Dinckley Parish  
Dinckley  
Blackburn  
Lancashire

26<sup>th</sup> February 2024

Planning Application No: 3/2022/0841  
Grid Ref: 368807 435935 Site Area 0.03 Hectares  
Proposal: Change use of an agricultural strip of land to use as an allotment & pond  
Location: Land to the rear of Greystones, Kenyon Lane, DINCKLEY. BB6 8AN  
Proprietor Address: Pendle View, Kenyon Lane, Dinckley, Blackburn BB6 8AN  
Dear Kathryn Hughes

Title: Site Plan & Viewpoints

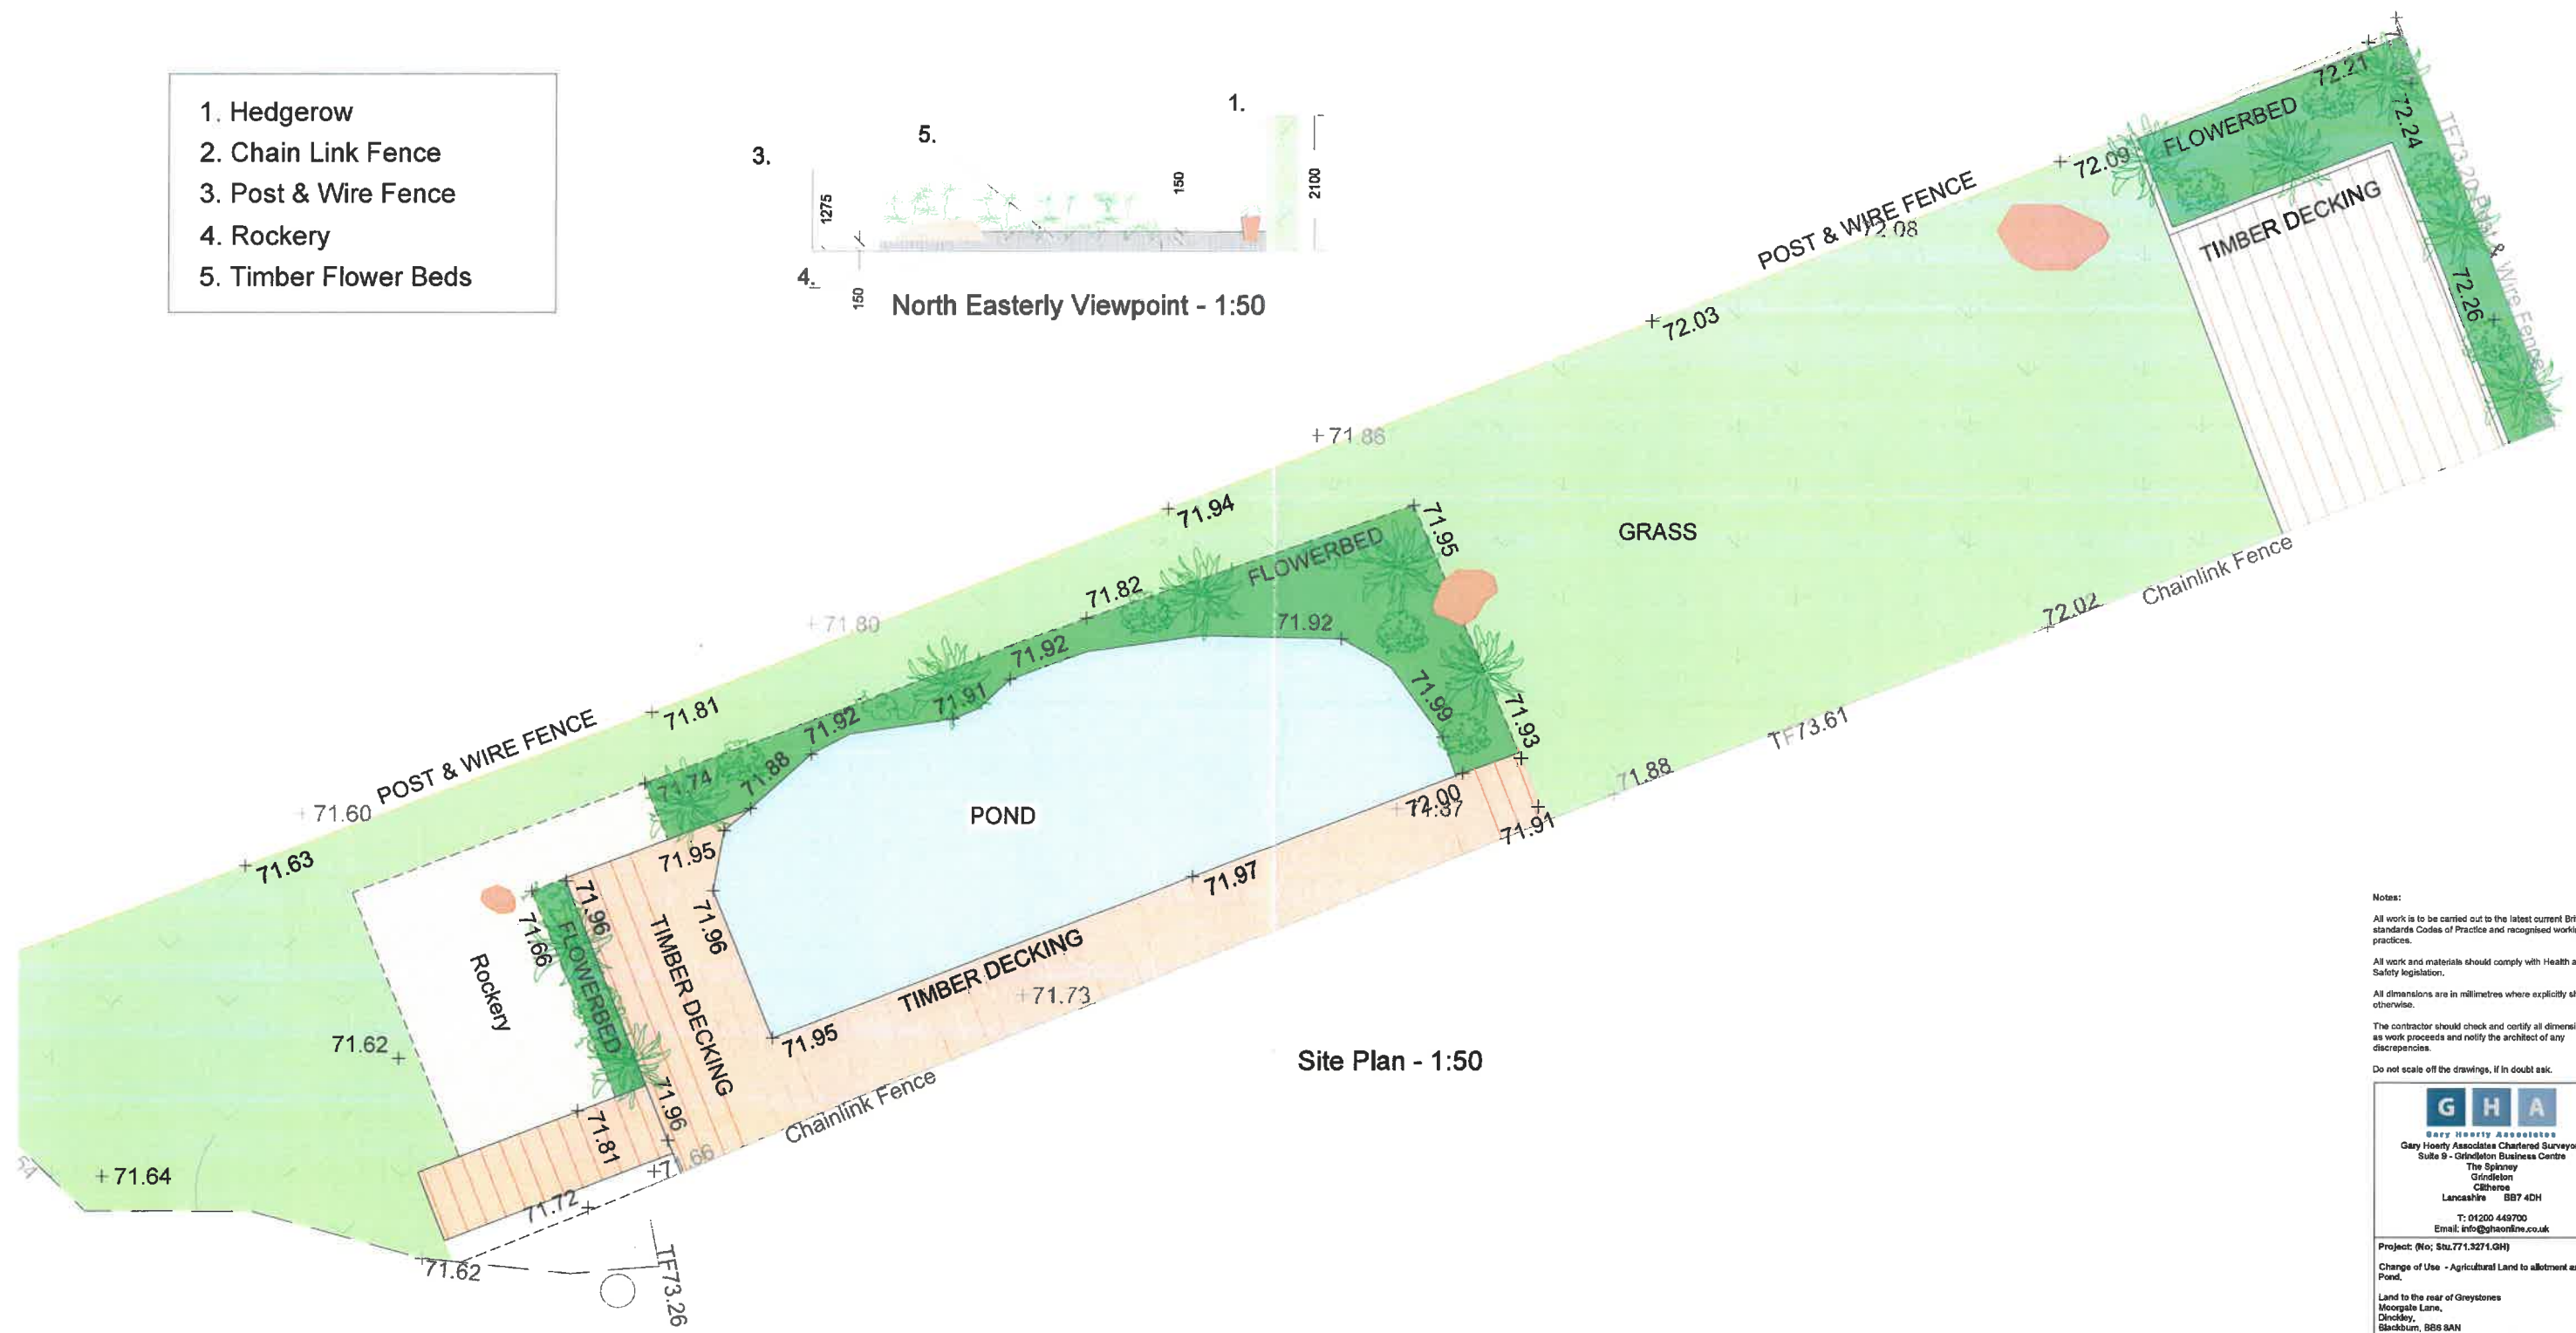
Firstly, there are some anomalies to the present existing site plan.

1. The Allotment listed as Greystones belongs to Merlewood House.
2. There is no longer an Outdoor Swimming Pool at Greystones House.
3. Existing plans are not what is in situ at the present - the full pond, rockery, decking and lawned area in the plans have already been built and erected without planning permission.
4. Double vehicle gates – there is has no planning permission been approved for vehicle gates only to gain access to the Allotment by foot.
5. Several Trees are missing that should be in situ but have been felled.
6. Greenhouse has now been dismantled.
7. The Shed has not had permission for the added structure on the side, this should not be on the plans.
8. The application does not advise that the Allotment site is close to and adjacent to a Roman Road, which is of geological conservation importance. The Roman Road runs through the garden and house of Greystones House.

The plans in this location are not in fitting with the environment and do not resemble an Allotment for this area and setting. With an addition of decking and seating, this is for recreational use, with what we belief the pond to be adapted and used as a wild swimming pond, this would then create noise and disturbance to adjoining residents and wildlife, especially if part of the bigger Camping Application.

The plans are for an ornamental garden with flora and fauna and materials not in keeping with the natural habitat, going against Policy DME 3 Site & Species Protection Conservation so affecting biodiversity in an Agricultural environment with Sheep livestock in the adjacent field. There is no reference to the plants that have already been planted, which could be detrimental to wildlife and livestock. There is no reference for this Allotment for this be used for Agricultural use to grow vegetables and fruit of which was the basis of the Approval of the previous Allotment for this open countryside area.
